Application for Planning Permission

Development: 1 No 4 bed chalet bungalow. This application is in CIL Zone 4 and is CIL Liable as a new dwelling.
Location: Dawn Cottage 44 Pagham Road Pagham PO21 4NP

Proposed North Elevation 44A

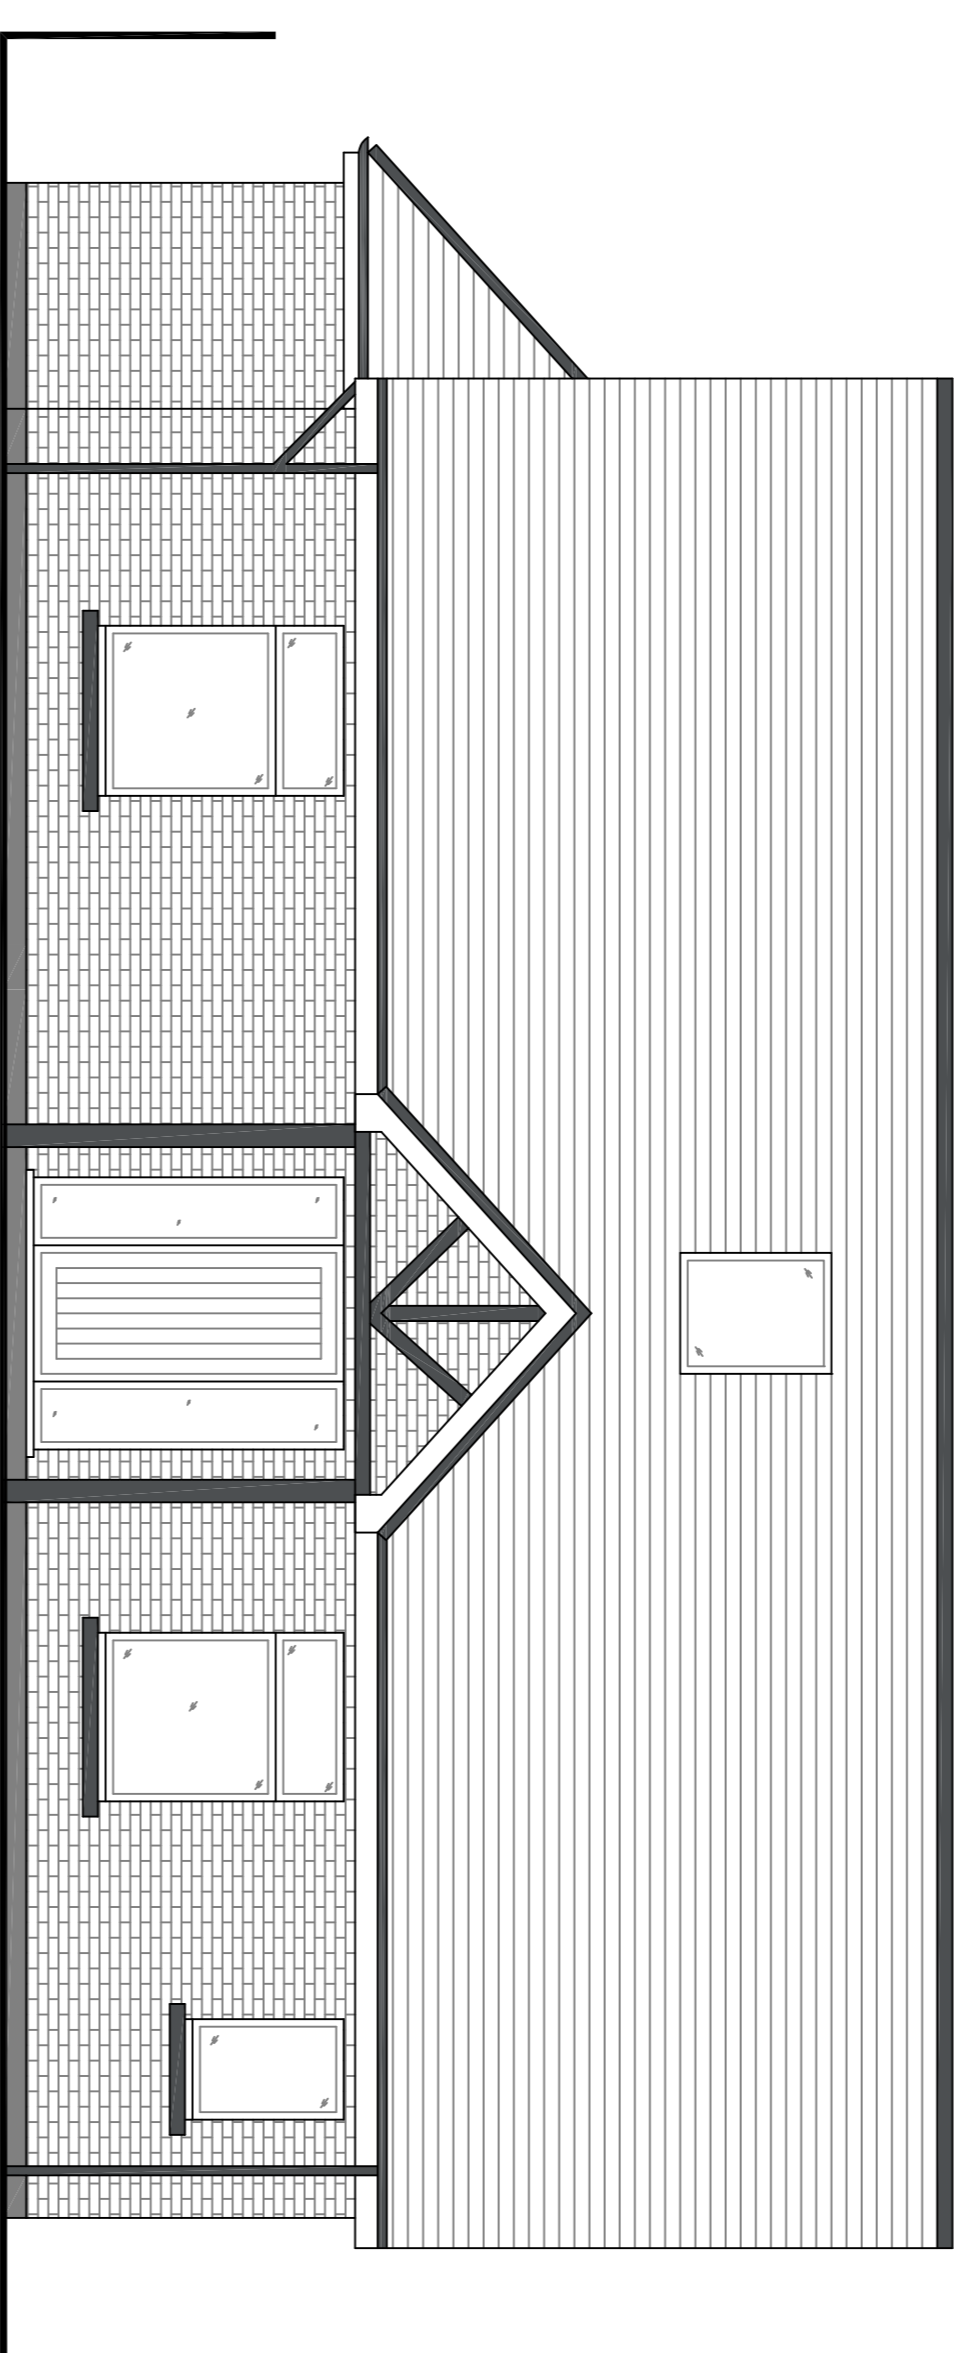
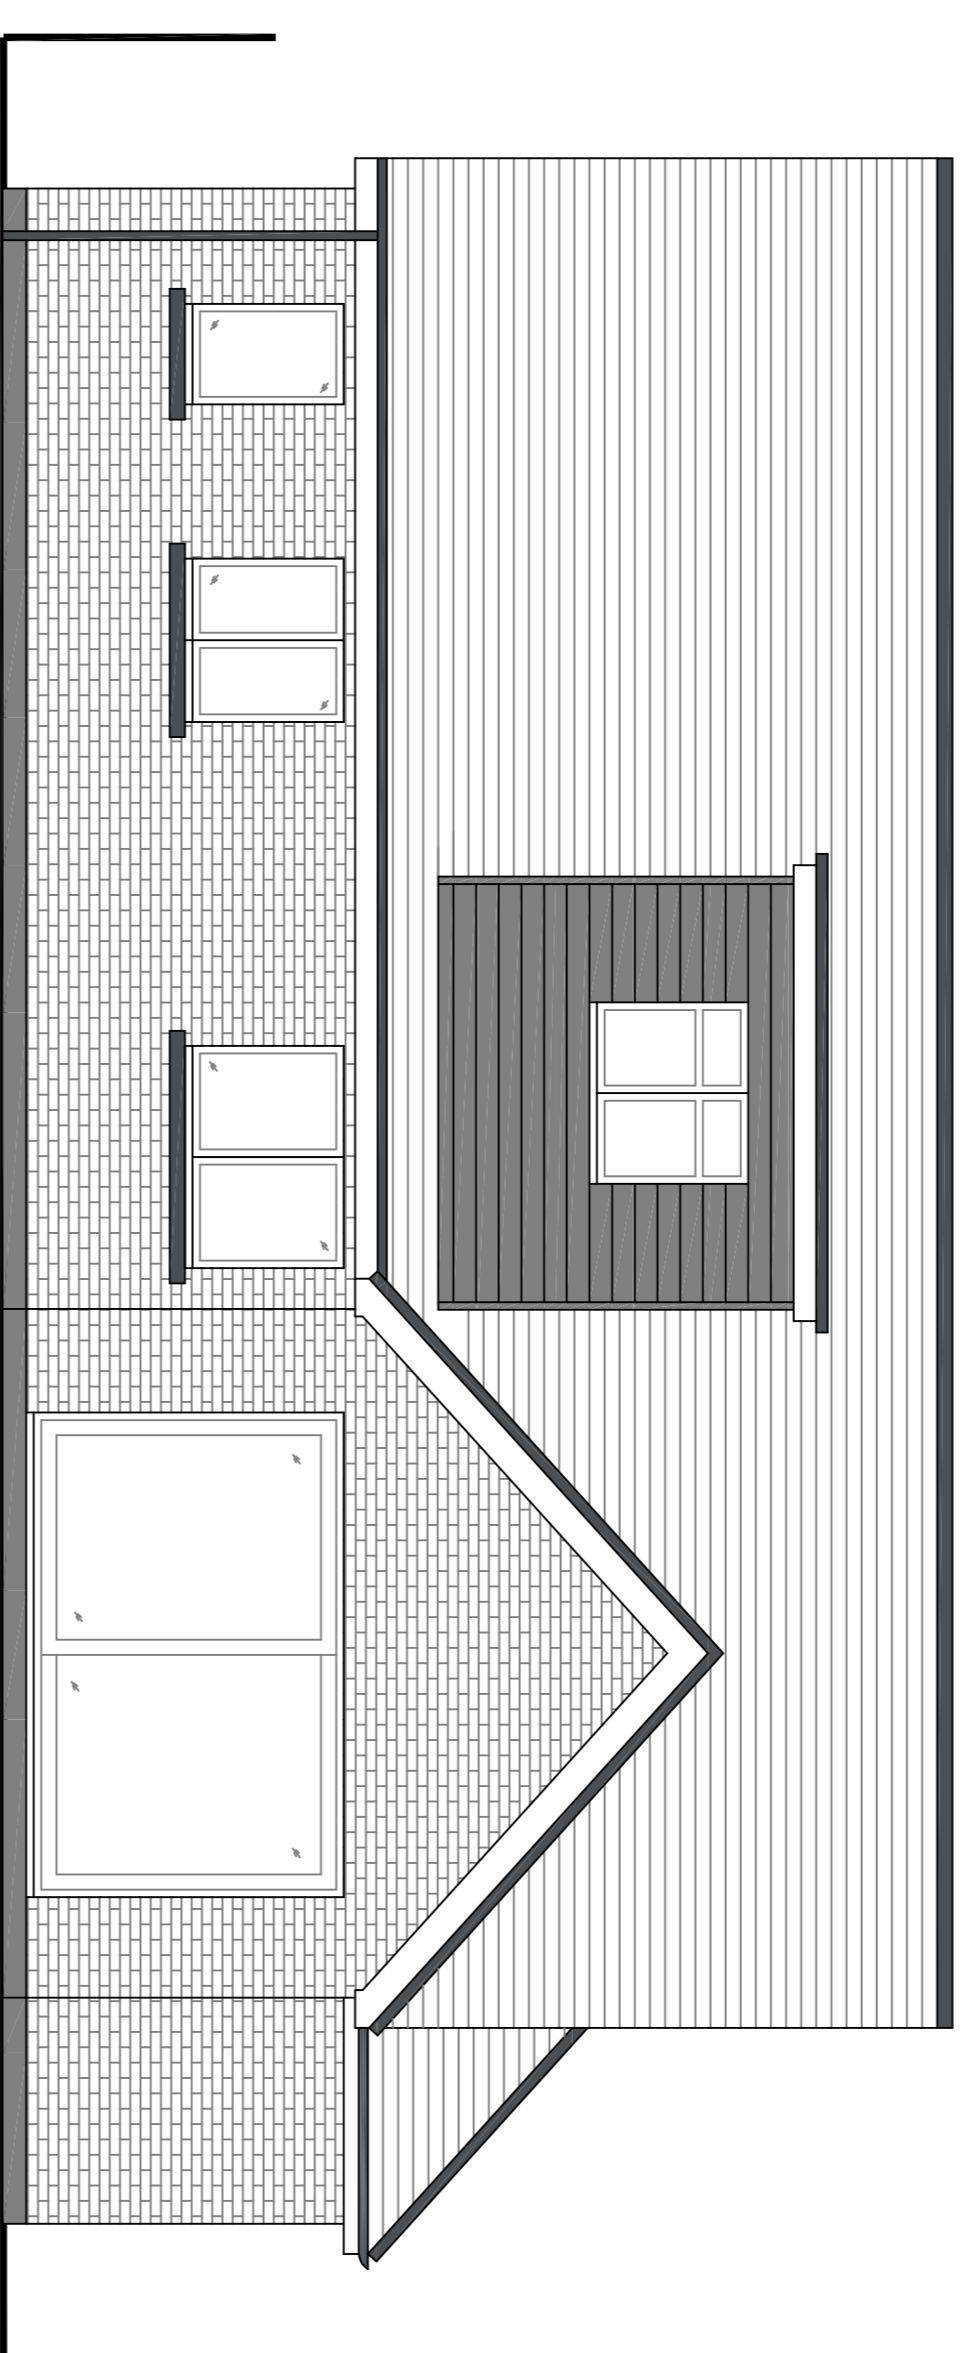
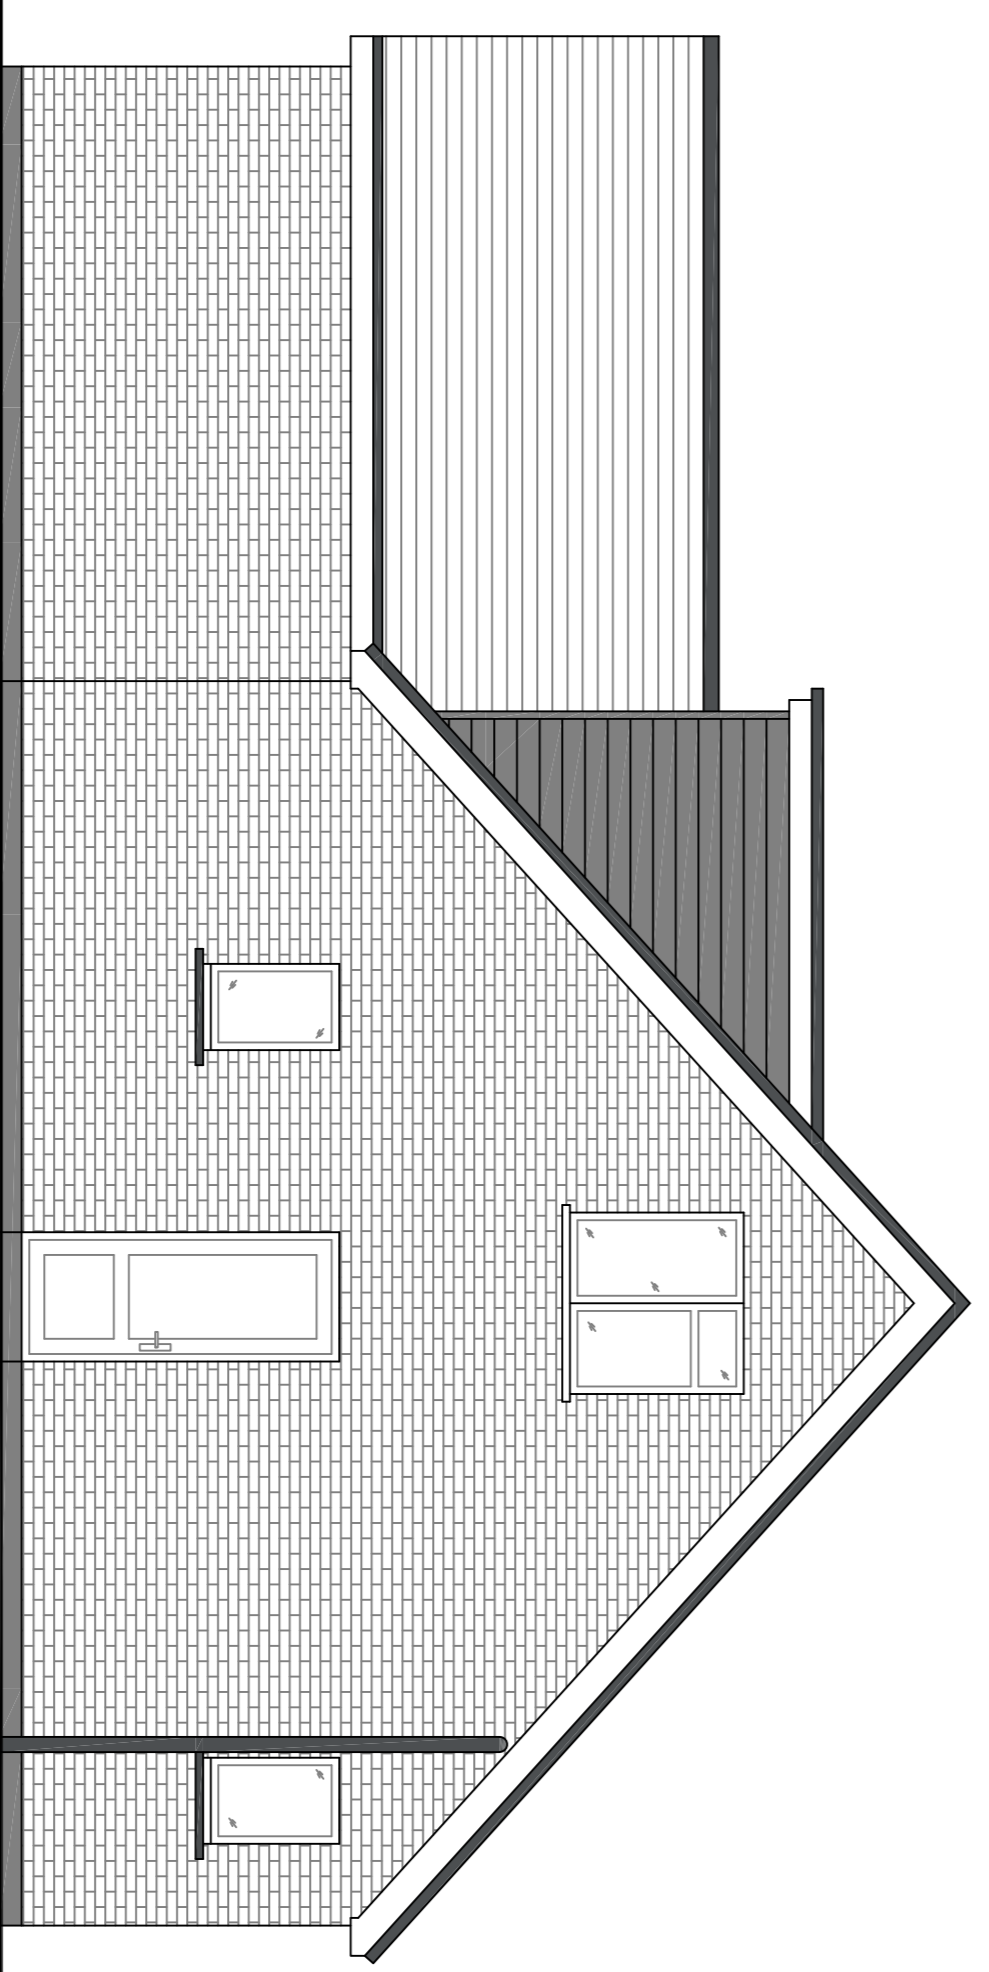
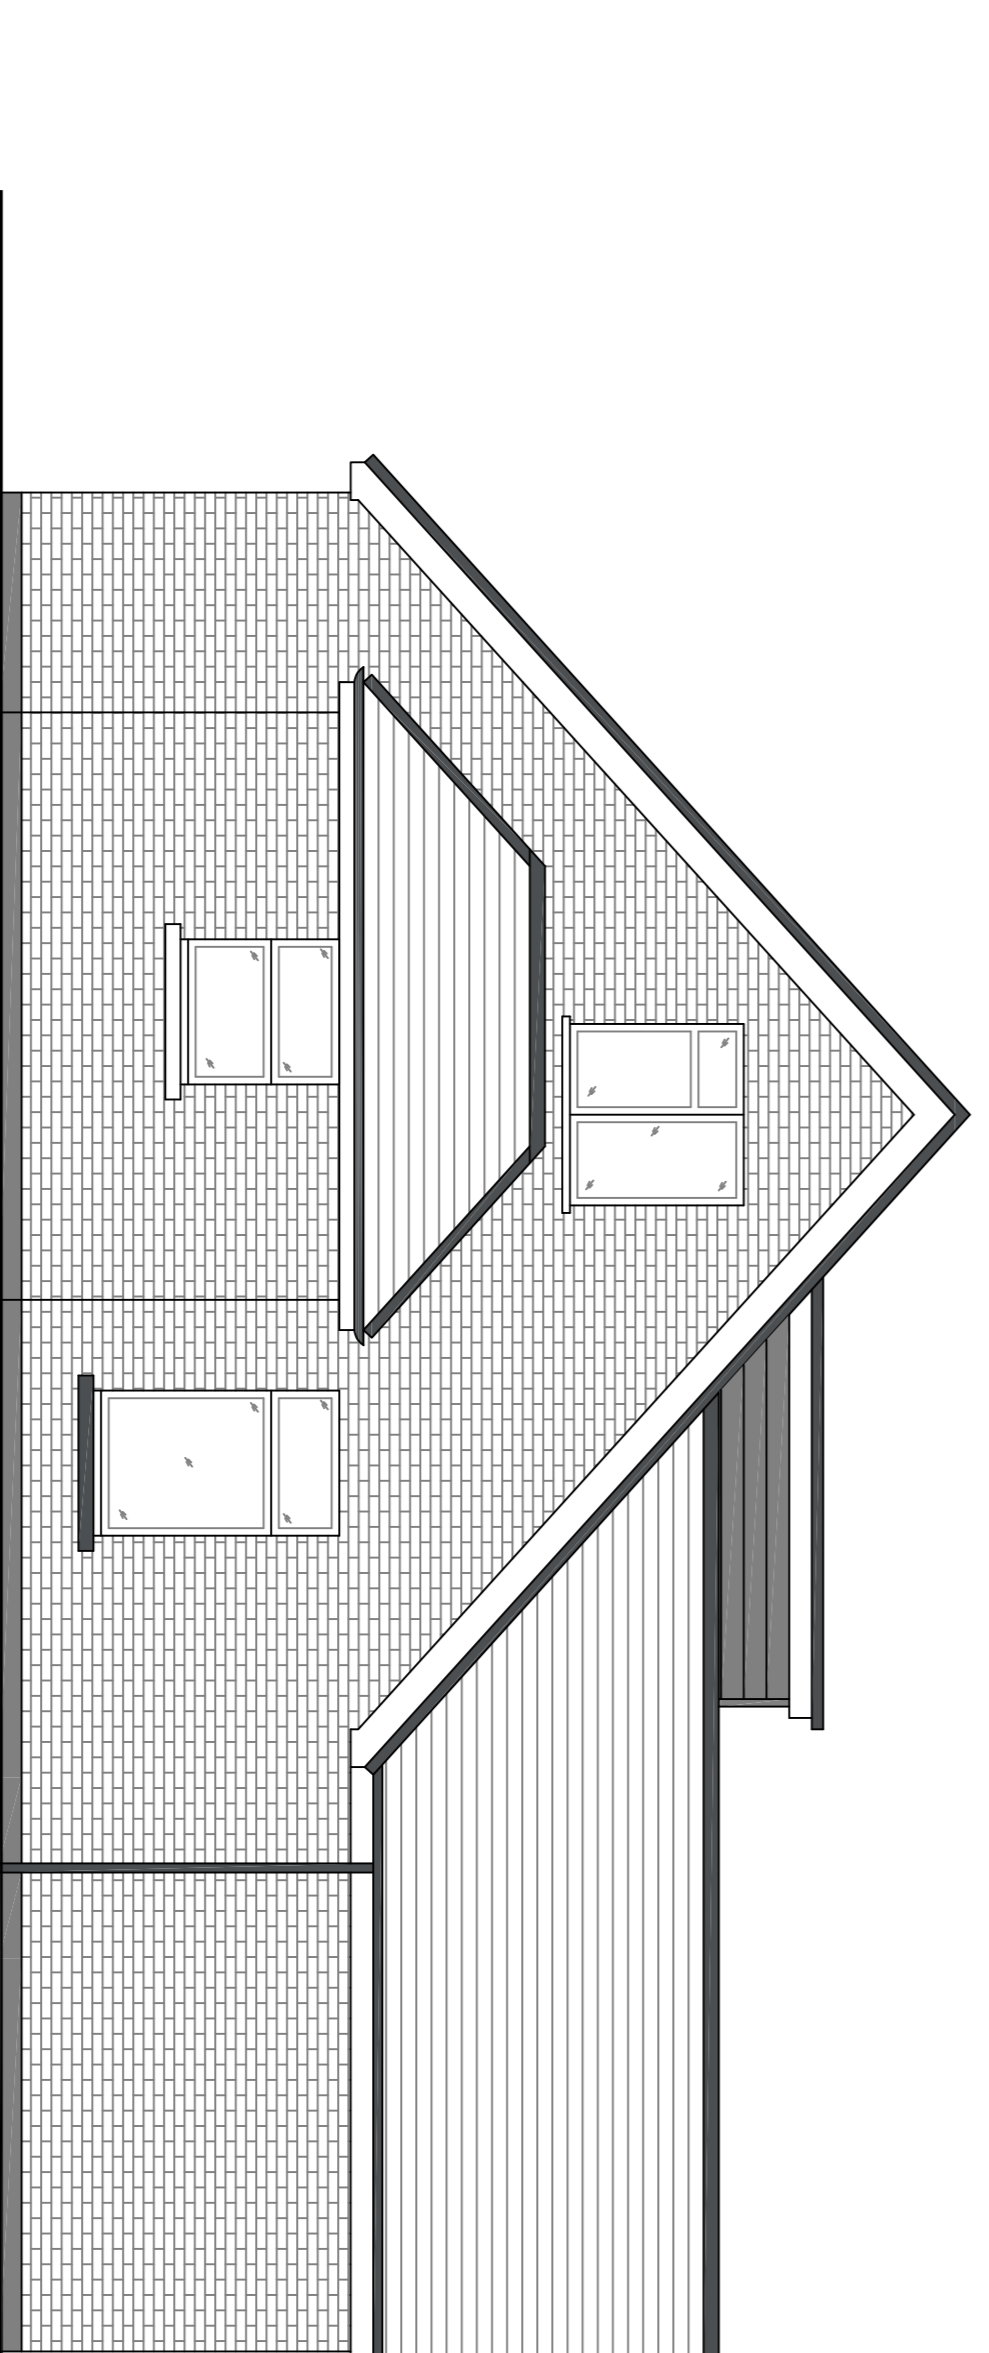
Please confirm why you have supplied two existing and proposed north and south elevations and east and west elevations as the elevations are the same.
